CITY OF ALBUQUERQUE

February 21, 2019

RE: Warehouse
7601 Los Volcanes RD NW
Grading and Drainage Plan & Drainage Report
Engineer's Stamp Date: 02/05/19
Hydrology File: J10D002G

See Gr-2 for Continuation

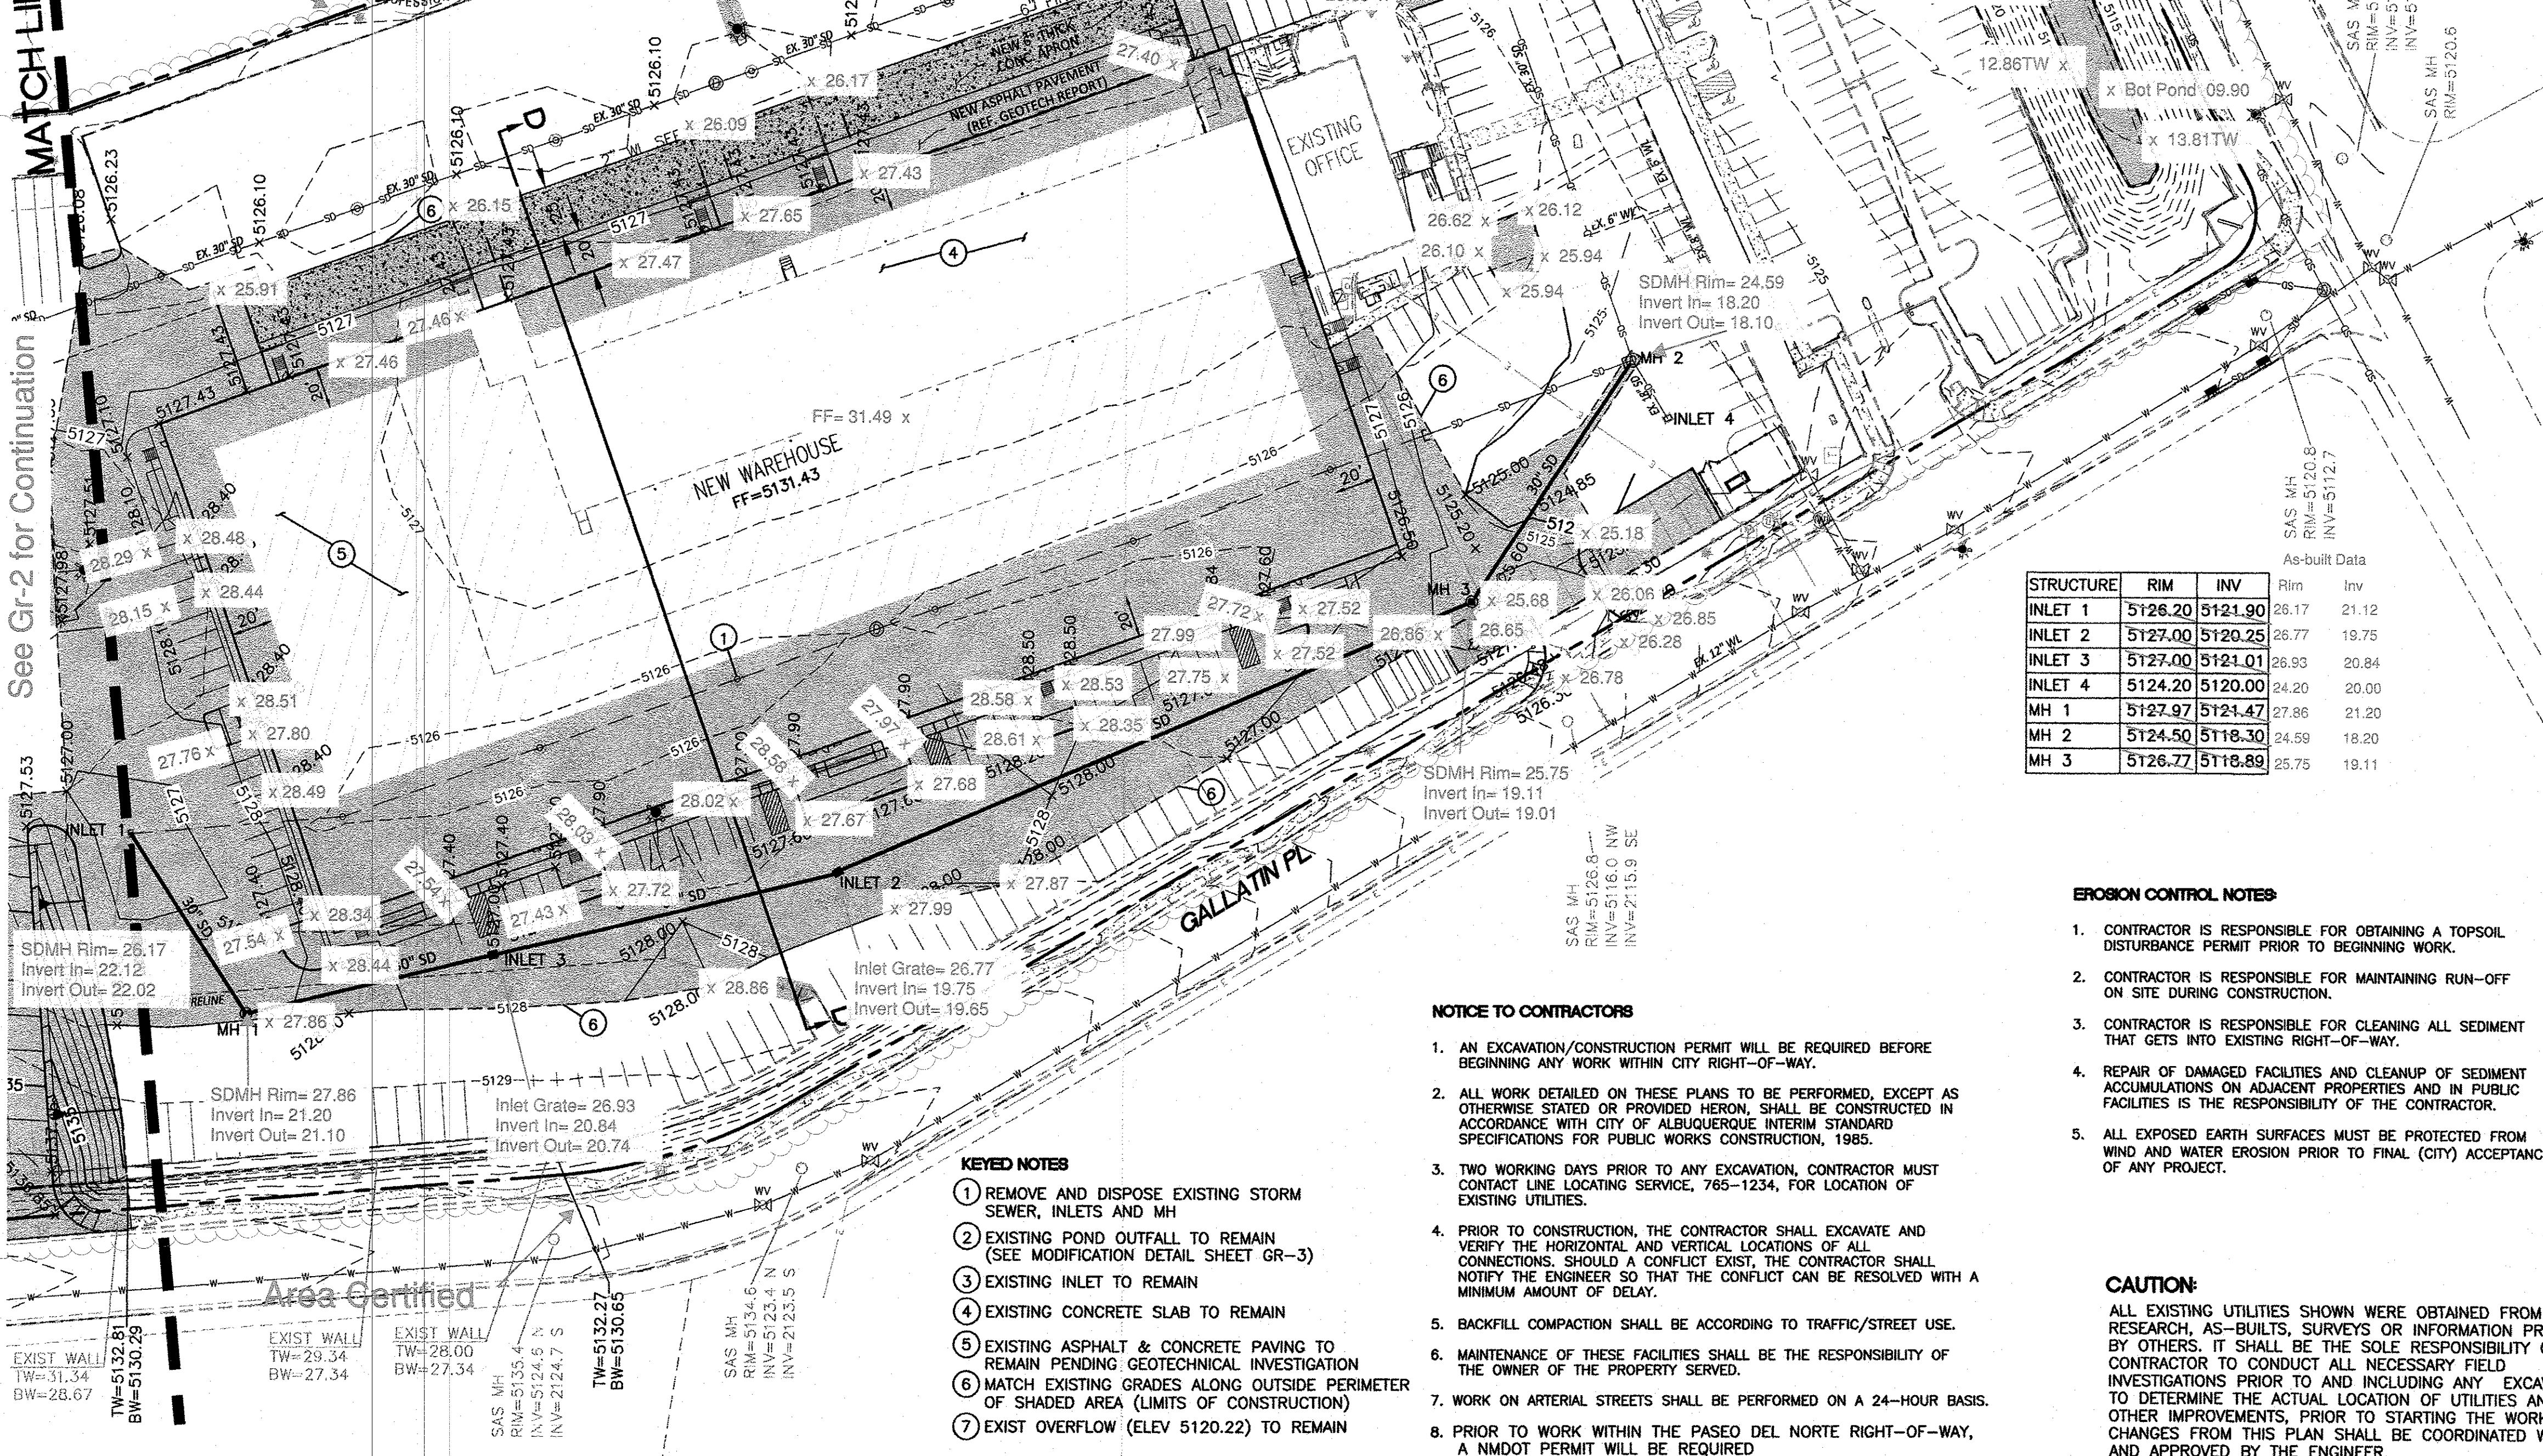
1. Sheet GR-1 & GR-2. Please clean up the Grading Plan. Whatever is going to be demolished, then please remove. Anything that is existing make lighter and anything that to be proposed, please make darker. I cannot make out what is proposed and what is staying. There are contours lines under the existing building. This doesn't happen. Also the existing building is the same line type as the proposed warehouse. Again please make the sheet better understandable of what is being proposed.

2. Sheet GR-1 & GR-2. Also if you are matching existing grades, then state this where you are doing so.
3. Please adjust the match line for Sheet GR-1 & GR-2. They currently do not line up.

SECTION C-C
NTS

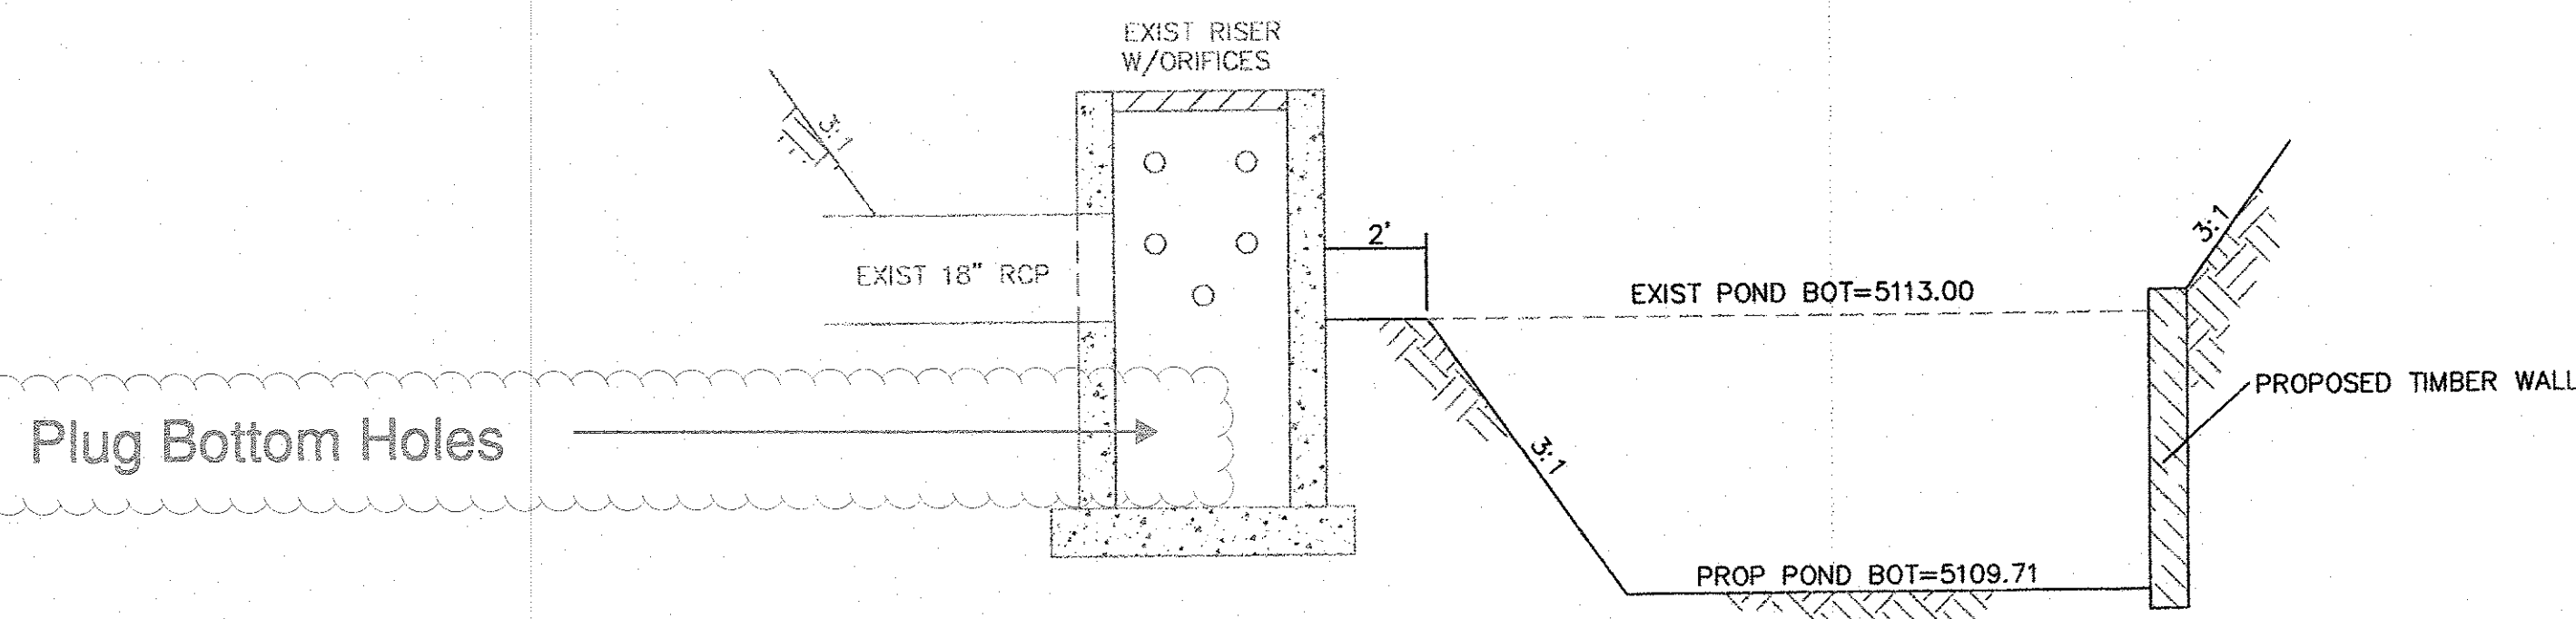
4. On Sheet GR-3, please add the WSE for the SWQ volume and the WSE for the 100 yr 6 Hr storm in Section C-C.
5. Drainage Report. Is the existing outfall structure functional? If so and will remain, please state so in the report.
